From: Laura Gibbons <Laura.Gibbons@arun.gov.uk>
Sent: 30 November 2021 15:30
To: Simon Davis <Simon.Davis@arun.gov.uk>
Subject: RE: FW: Planning Consultation on: A/212/21/DOC

I just want to clarify our position. They have made this application for a re-discharge solely to change the resin bound gravel drives to porous block paving. They state that this has been made to aid the draining of the driveways from surface water and to provide a more robust and attractive finish to the drives. They initially applied for this under an NMA but I said we couldn't deal with it through a NMA as we would need to consult drainage engineers so we have this DOC.

Formpave Diffuser tank construction

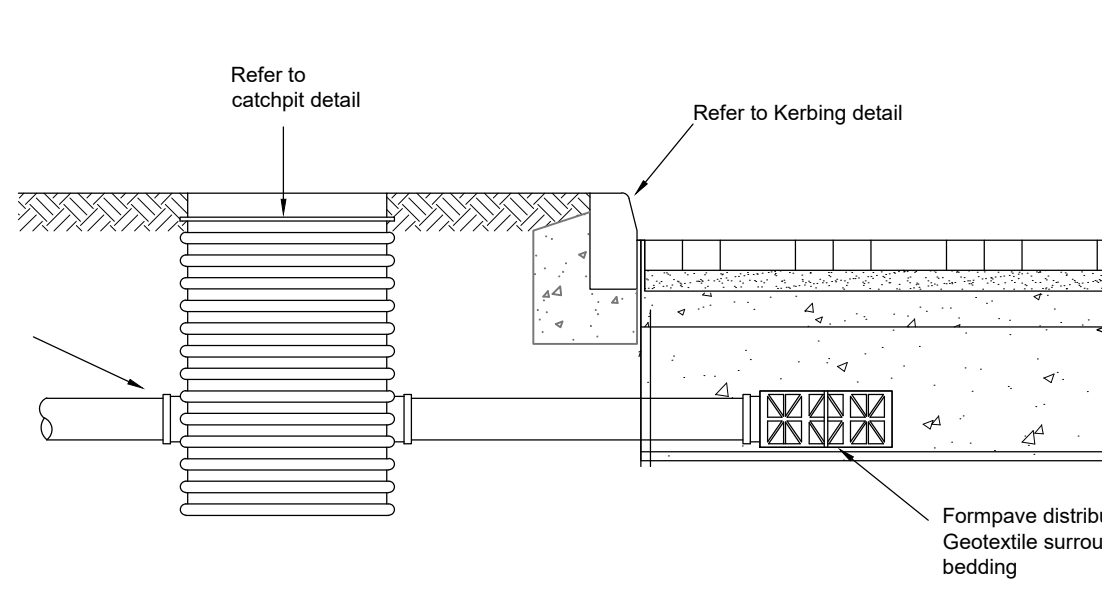
I've given the latest proposals another review. Due to an explanation provided I no longer require diffusers to be located above 1 in 10 year plus CC event. However, there is an error on the layout, which shows a diffuser unit 1m below the formation level. Which is no good.
